SC-18-063

EL PASO COUNTY PLANNING & COMMUNITY DEVELOPMENT
SIGN APPLICATION

Name: **STRABWICKS**
Address: **209 GLENKLE**
CATE VIEW
Zone: **C5**
Legal Description: **LOT 2**
ACADEMY GATEWAY
SUB HL NO 1

NEW SIGN ON WEST ELEVATION

ELEVATION @ ENTRY
 Scale: 3/16" = 1'

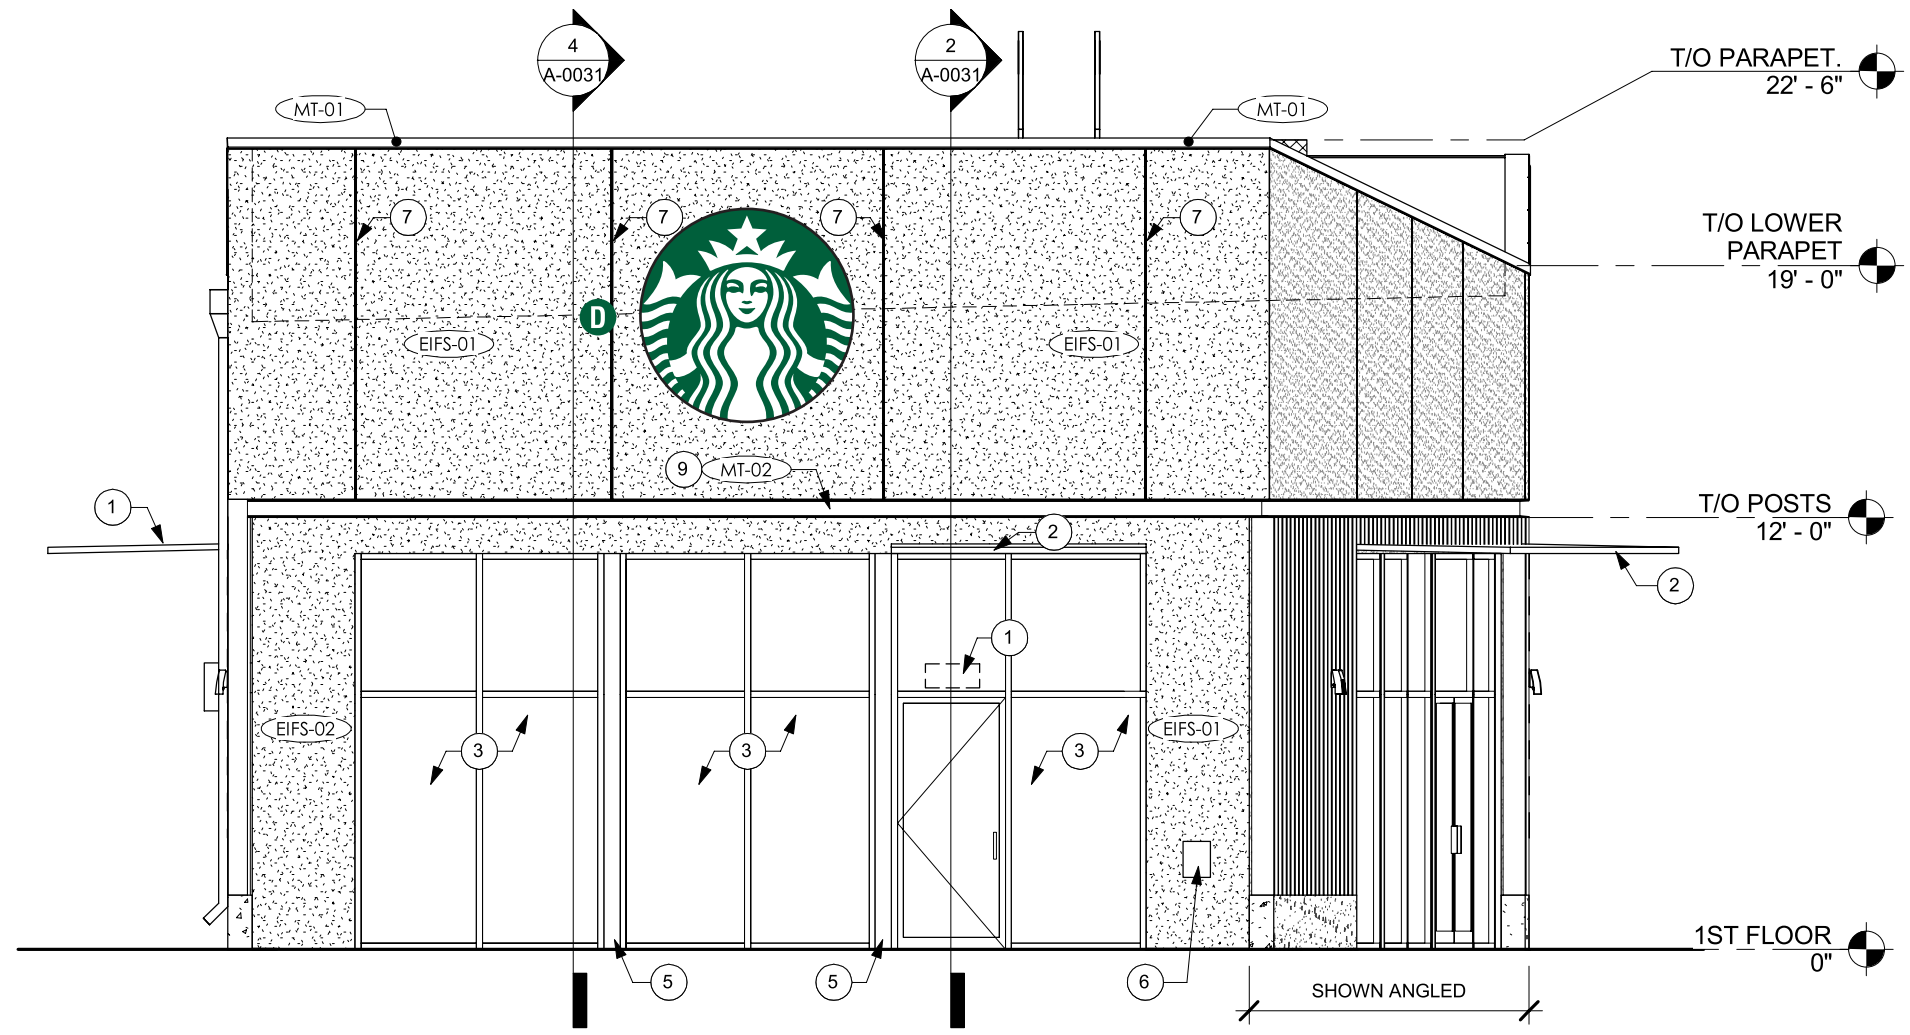
Since this only pertains to one sign, please only include the width of that wall, and the sign on that wall in square feet, also update your drawings to include the actual measurement of the wall being applied for.
